Response to Planning Application

From: Arun District Council Greenspace

Application ref: A/64/21/PL

Location: Former Shrublands Nursery Roundstone Lane Angmering BN16 4AT

Figure 12 - Proposed Site Layout

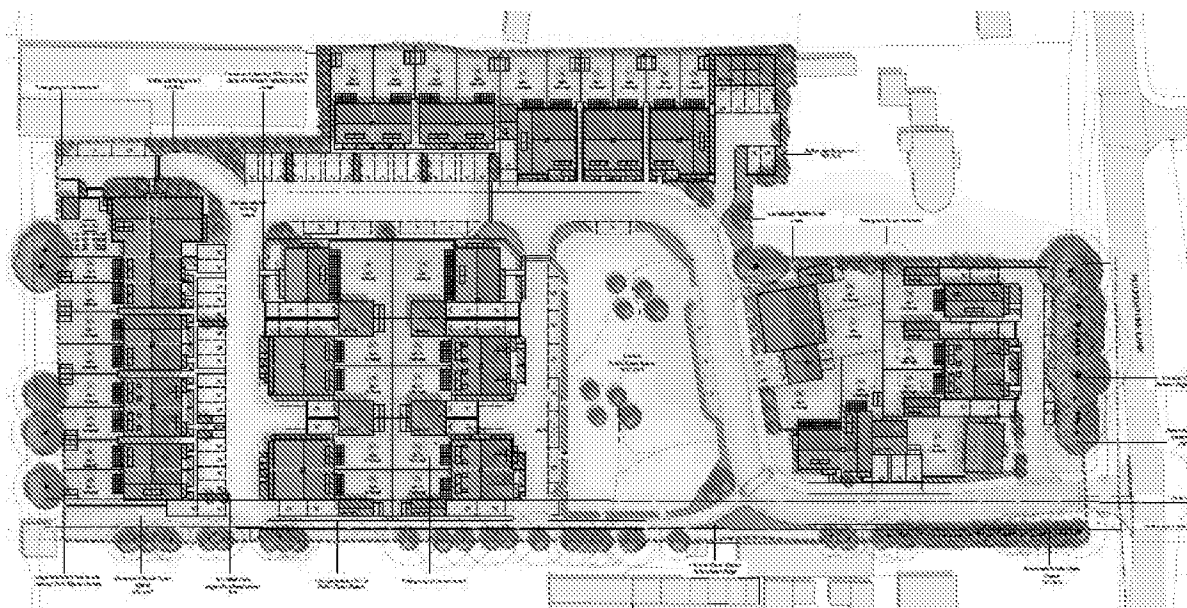
The indicative layout has shown 40 dwellings within the proposals with an area of POS, located centrally to the development and buffer planting to perimeter, shown as movement routes and buffer zones. Consideration appears to have been given to facing dwellings onto POS areas in line with good design principles.

A development of this size will require the provision of onsite POS minimum area of 3300m² plus the provision of onsite, equipped play LEAP to contain at least six play experiences to be accessible and inclusive and onsite natural play LAP area to include such features as landform, boulders or logs, seat and litter bin. **Confirmation of the area of POS being proposed would be required as the areas shown would appear to be deficient in line with our SPD requirements.** Open space areas to be included within the calculations must not include SuDS areas, small unusable or connective strips of ground.

The Site layout PL-101-Rev P1 shows the central open space area and also indicates that this area is to be a considerable drainage feature for this development. Trees are shown to be planted above and in this location. **Guidance should be sought re the suitability of including trees within/over the drainage provision shown.** Overall Drainage Strategy dwg 20-016-101-A.

Pedestrian and cycle routes within the development should be a considered design features and their meaningful connection to beyond the site detailed. It is unclear from the layout provided how this site connects to the wider network beyond its boundaries.

Recommend that confirmation of the areas of POS being proposed would be required as the areas shown would appear to be deficient in line with our SPD requirements. I would also recommend confirmation is sought re onsite play provision, which would be required but not shown. Tree planting as indicated over drainage provision to be checked.
